Arun District Bridleways Group

18 March 2020

Re: Ford Airfield Strategic Development Site – F/4/20/OUT

FIGURE 23: KEY PRINCIPLES PLAN – PEDESTRIAN AND CYCLE MOVEMENT

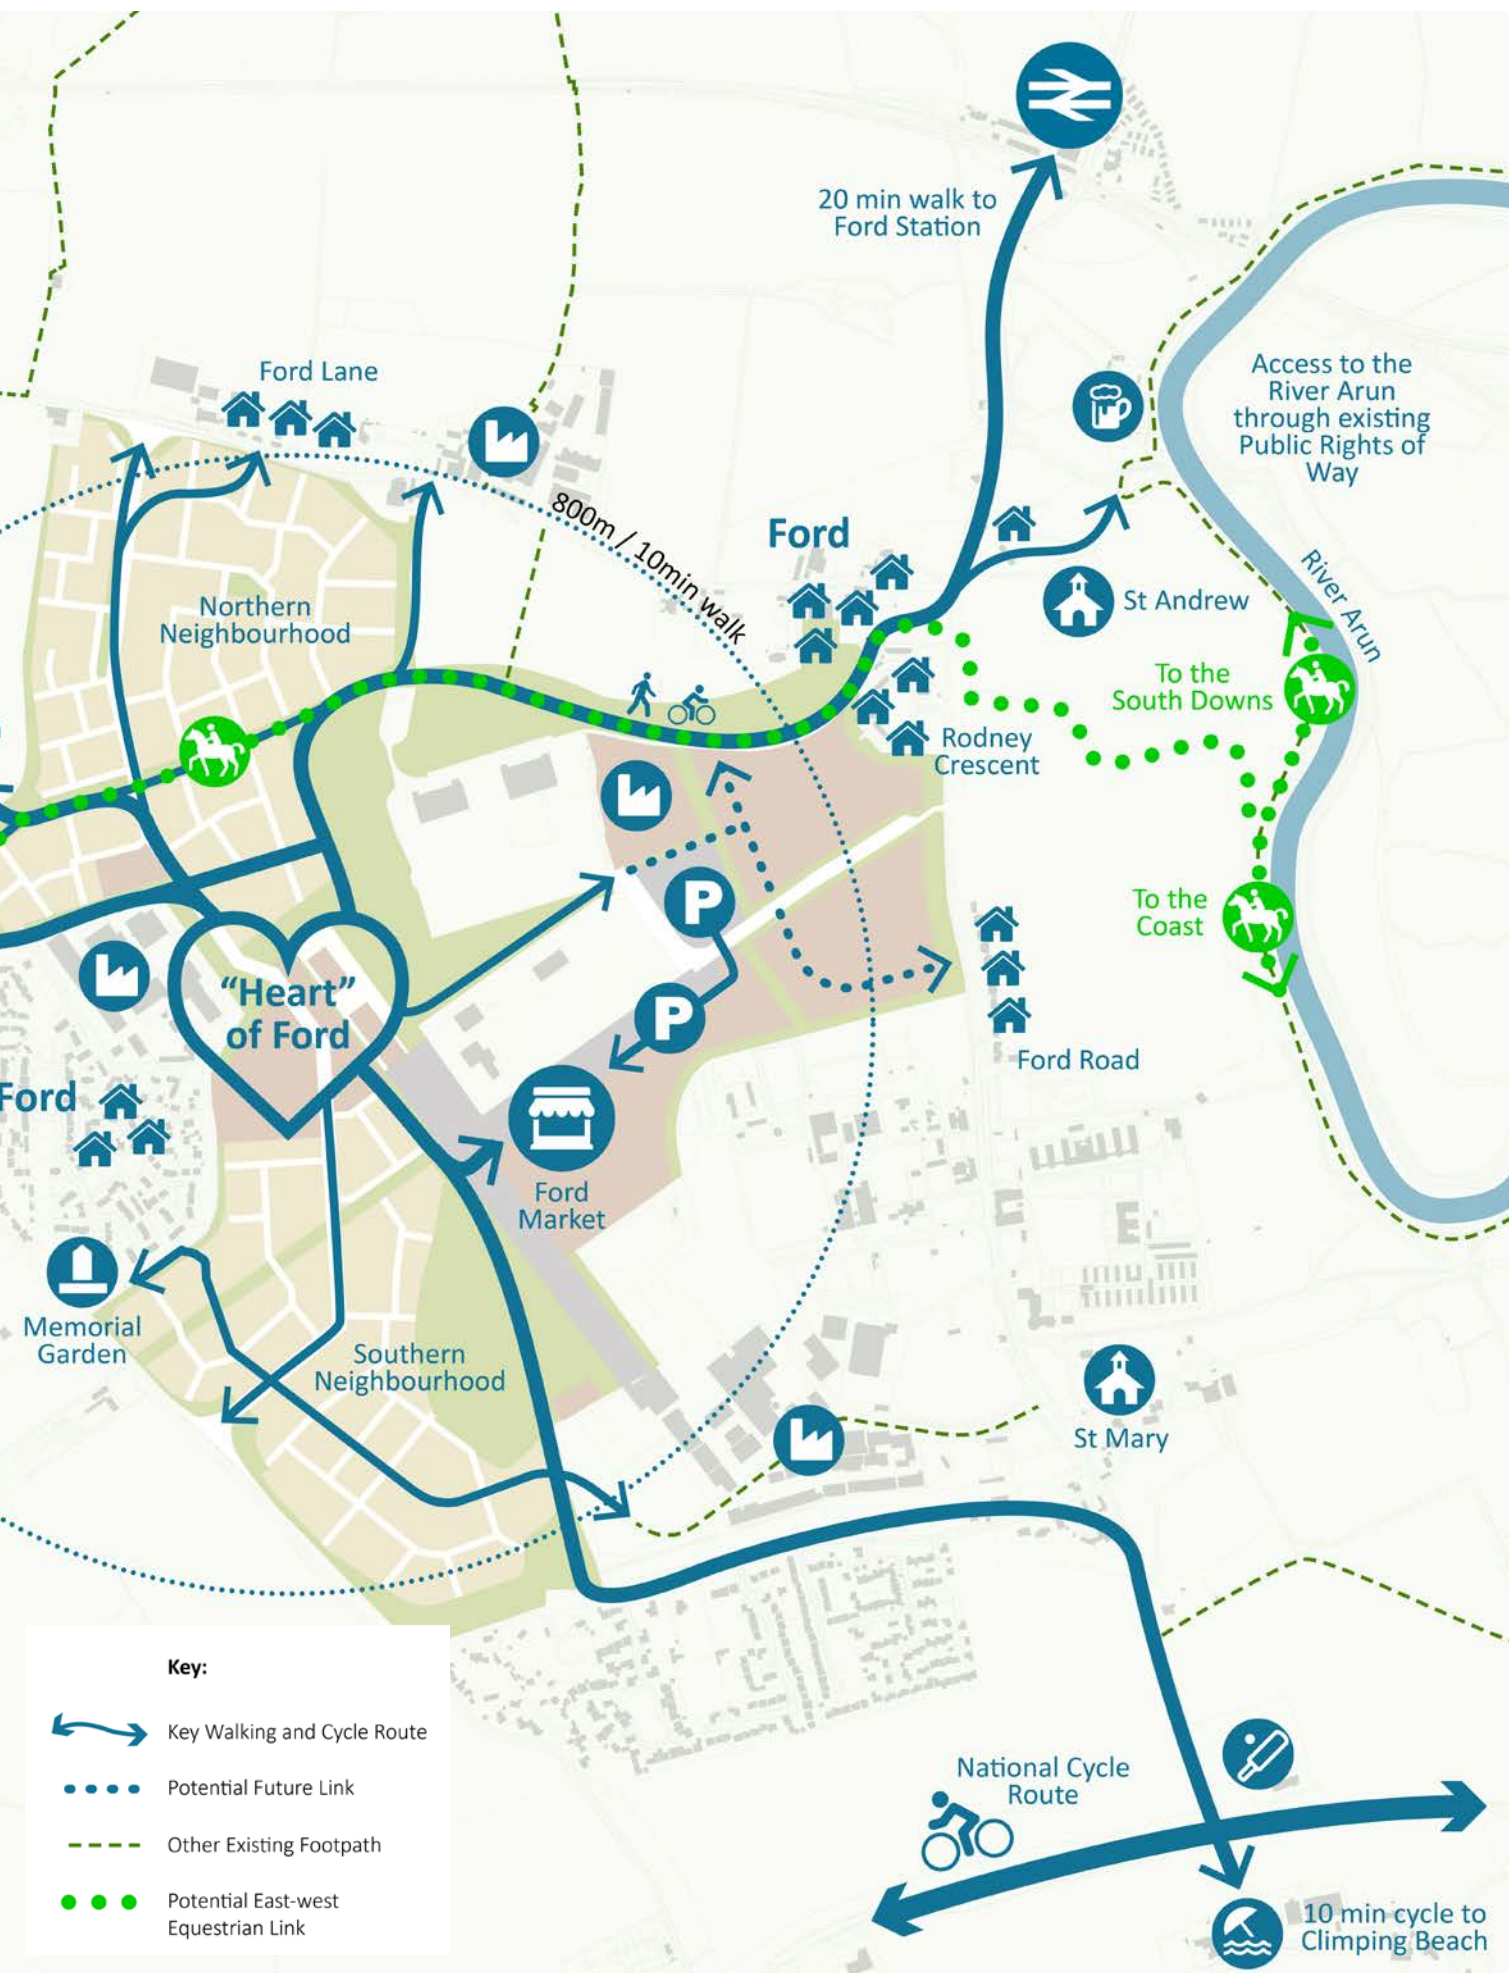
Firstly, there is no detail in relation to proposals for the old Ford to Hunston barge section of the Portsmouth & Arundel Canal route through the site which we, along with representatives of other vulnerable road user groups, would like to see re-purposed as a multi-user greenway, providing a safe off road east/west communication and leisure route along the coastal plain, enabling such users to avoid the increasingly busy coastal plain roads. The opportunity should not be lost to secure as much of the canal route as possible, not just the existing footpath, and agreement for upgrade to at least bridleway status from the landowner/developers.

This large site should also be providing a north/south bridleway in line with the West Sussex Transport, Arun District Local Plan and West Sussex Rights of Way Management Plan policies, or where highlighted as deficiencies in the current local provision as follows:

Enhanced local community access for local cyclists and horse riders at both Ford, Climping and Yapton, with possibilities for being able to make circular routes or use the path as part of a commuter route, could also be achieved by the upgrade of the airfield perimeter Footpath 175 to bridleway with provision of a link to Horsemere Green Lane.
